CONSERVATION COMMENTS	
Application Number	SDNP/24/00595/DCOND & SDNP/24/00597/HOUDS
Proposal	Discharge of Conditions 3 and 4 on SDNP/23/00732/LIS and SDNP/23/00731/HOUS
Case Officer	Karen Wooden
Date	13 February 2024
<p>The original LBC and planning consent granted permission for “Conservation and repair works. Minor external and internal alterations and improvements. Construction of garage building and outbuilding comprising garden room and store. Landscaping works.”.</p> <p>Both were subject to the following conditions:</p> <p>3. Notwithstanding the submitted details, no works shall be carried out above ground floor slab level until a schedule of external materials finishes and samples to be used on the main dwelling hereby approved has been submitted to and approved in writing by the Local Planning Authority. Thereafter the development shall be carried out in full accordance with the approved schedule and samples.</p> <p>4. No works shall be carried out above ground floor slab level until details of all new internal and external door and window joinery and metal frames shall be submitted to and approved in writing by the Local Planning Authority. The submitted details shall incl

**Condition 4 - Material  
schedule - Corner glazing system**

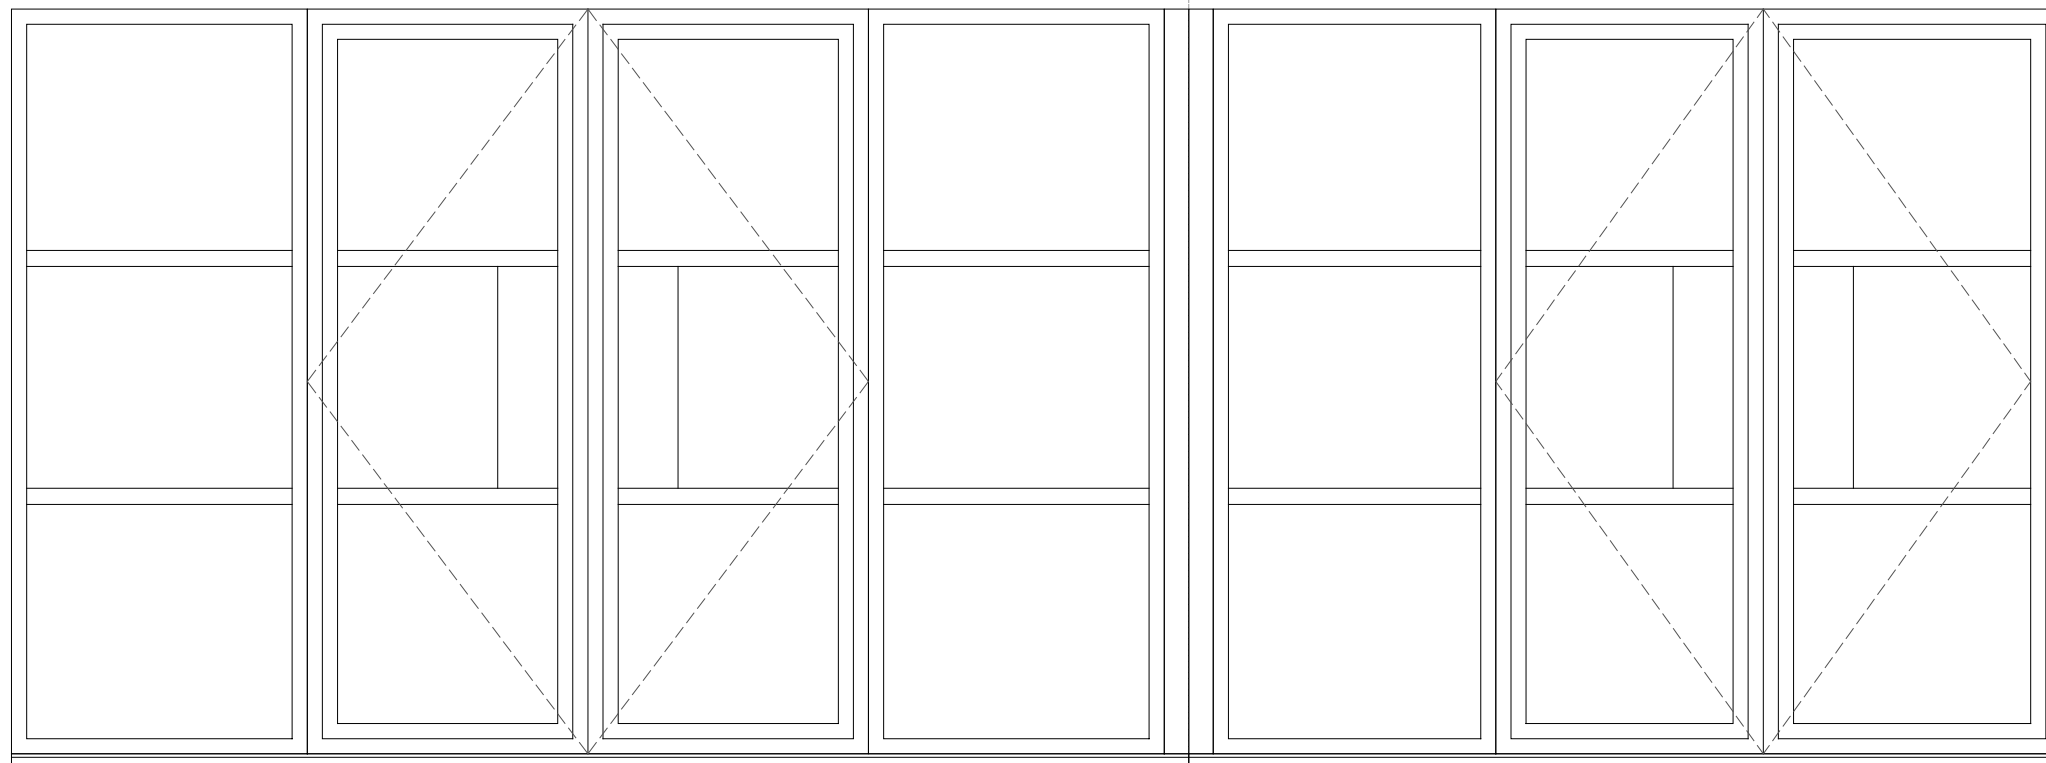
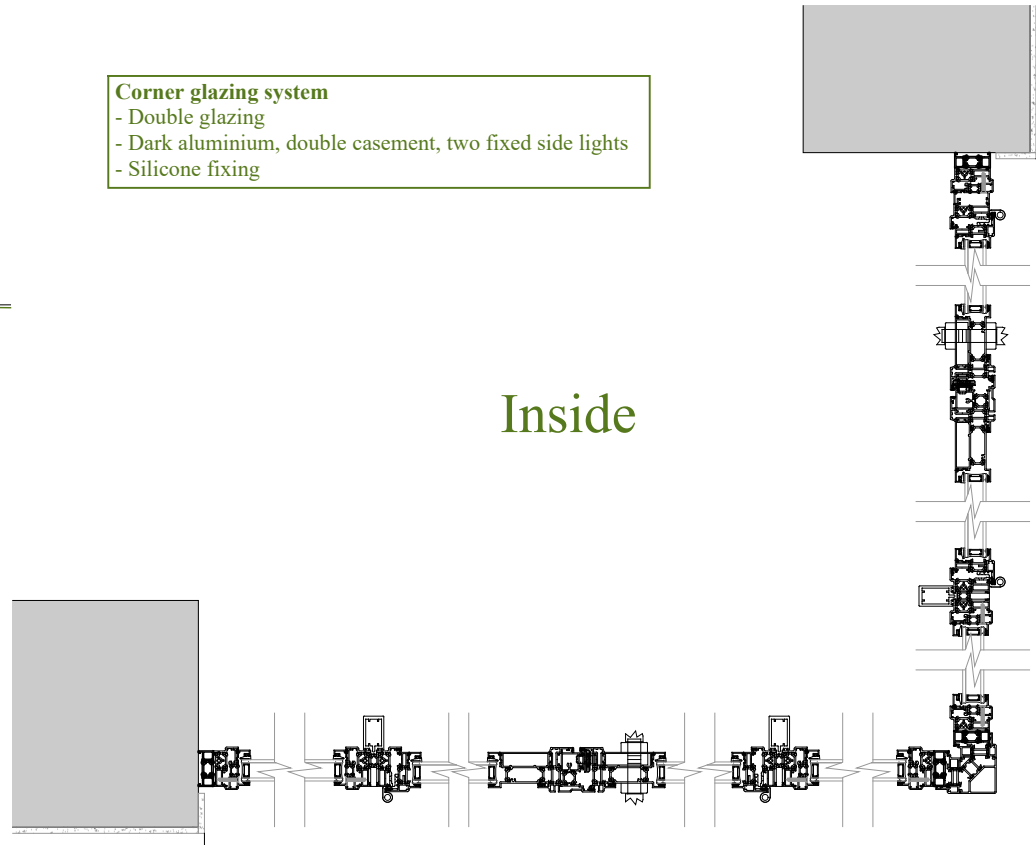
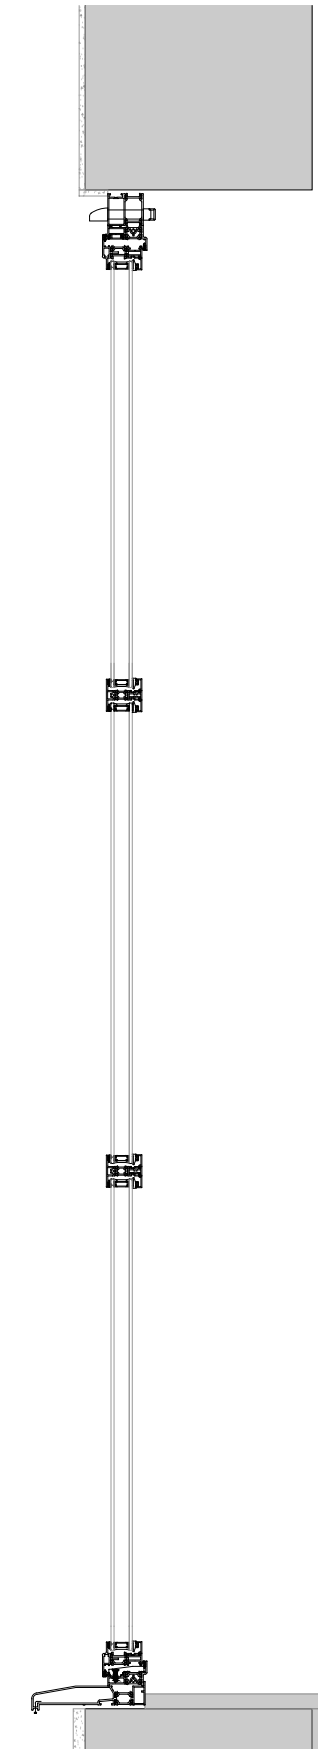
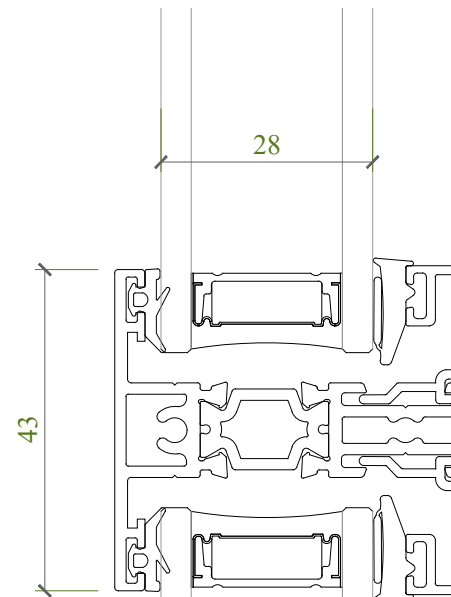
Finally, the documentation shows a proprietary aluminium glazing system - we did accept the use of such on one end of the main cottage as it is a later extension. As normal with such systems, it is double-glazed. The colour still needs to be specified more specifically than "Dark".
